Town & Country Planning Act 1990 (as amended)
Town & country Planning (Development Management Procedure) (England) Order 2015

Loft conversion & rear extension
63 Midhurst Drive Ferring

SIDE ELEVATION (EAST)

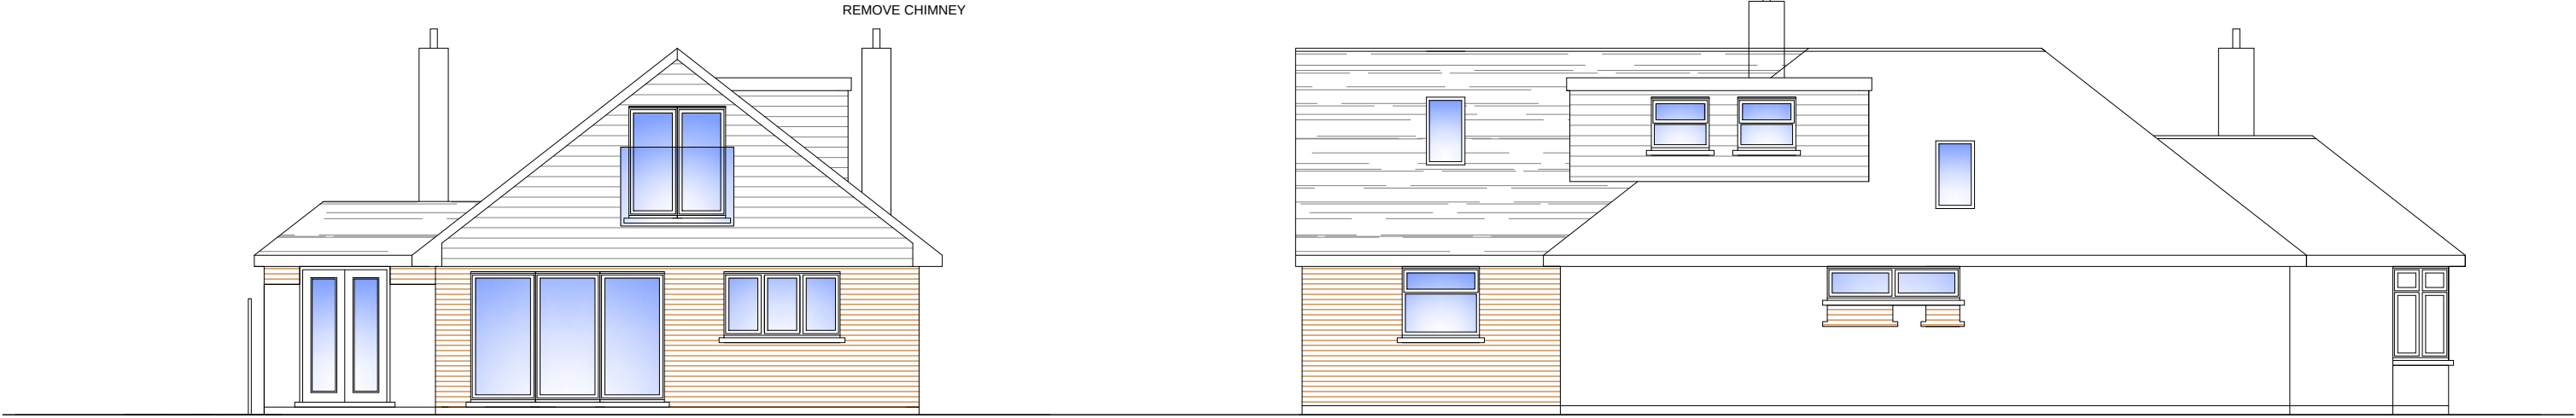
Ferring Parish Council felt the plans are unclear relating to the proposed window aspects. Parish Councillors raised the concern in relation to the surrounding area and if the proposed loft conversion, particularly on the east side elevation will have an overbearing impact and overlook the neighbouring properties.
